April 26, 2021

Re: Trip Generation Traffic Assessment Letter
Peerless Farms
El Paso County, Colorado

PRELIMINARY PLAN
SHEET 2 OF 3

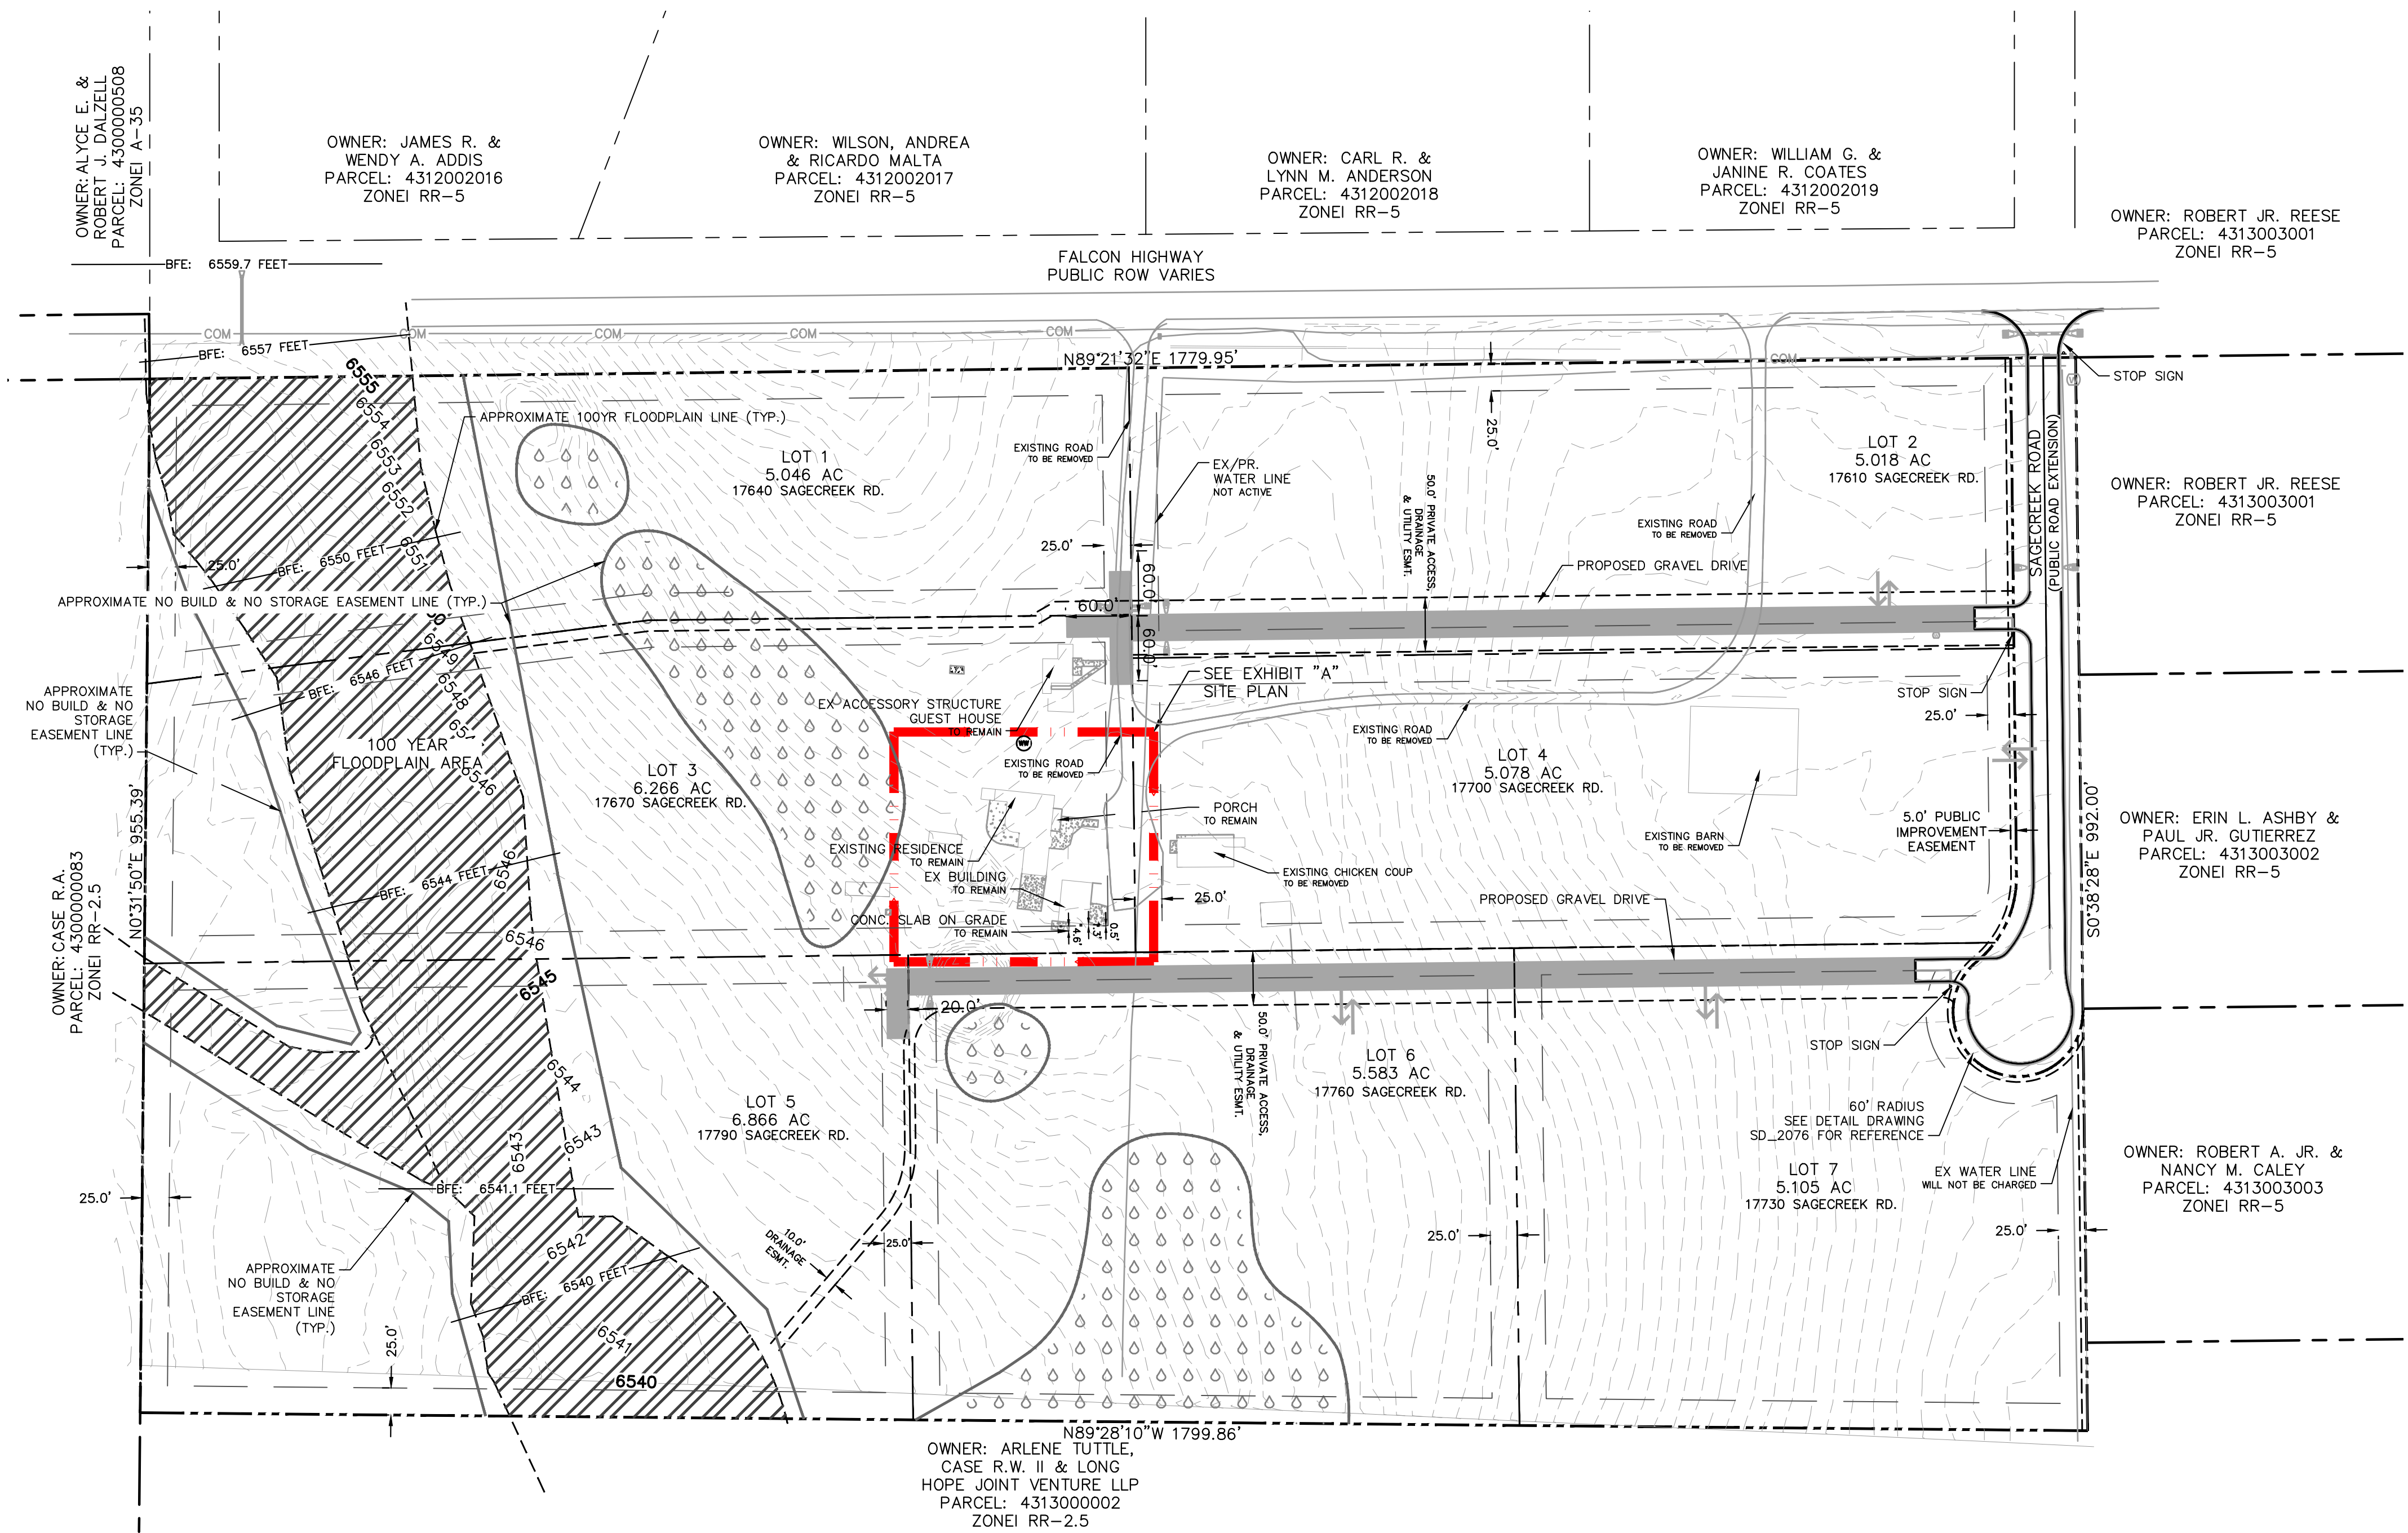
Address sight distance criteria at intersection

Be sure all items in ECM Appendix B paragraph B.1.2.D under the first bullet point are addressed.
